Planning and Regulatory. G.Mansfield  
PB2017/03348  
Phone: 02 4974 2767

## **NOTIFICATION OF MODIFICATION APPLICATION NEW SPACE PROJECT**

I refer to your email of 4 April 2017 advising Council that the University of Newcastle has submitted an application (SSD 6457 MOD 2 ) pursuant to section 96(1A) of the *Environmental Planning and Assessment Act 1979* to further modify the development consent of the above project and inviting Council to comment on the modified development.

Figure 2 – Approved and proposed Christie Place deck design

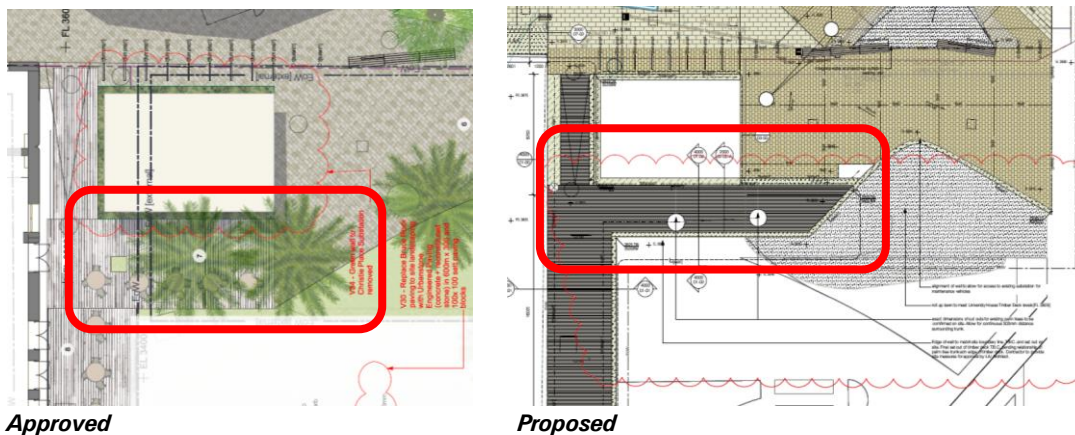
It is indicated that the proposed changes to the deck are minimal and will not result in any significant visual changes to the approved landscaping scheme. It is noted the approved modified landscape plan (MOD1) retains the four existing Palm trees in the vicinity of the substation.

The application was not supported by a modified landscape plan and therefore it not clear if the above trees are to be retained. The submitted layout and grading plan (LS-005 Version C) does not provide any details in this regard. Clarification should be sought from the applicant regarding this issue.
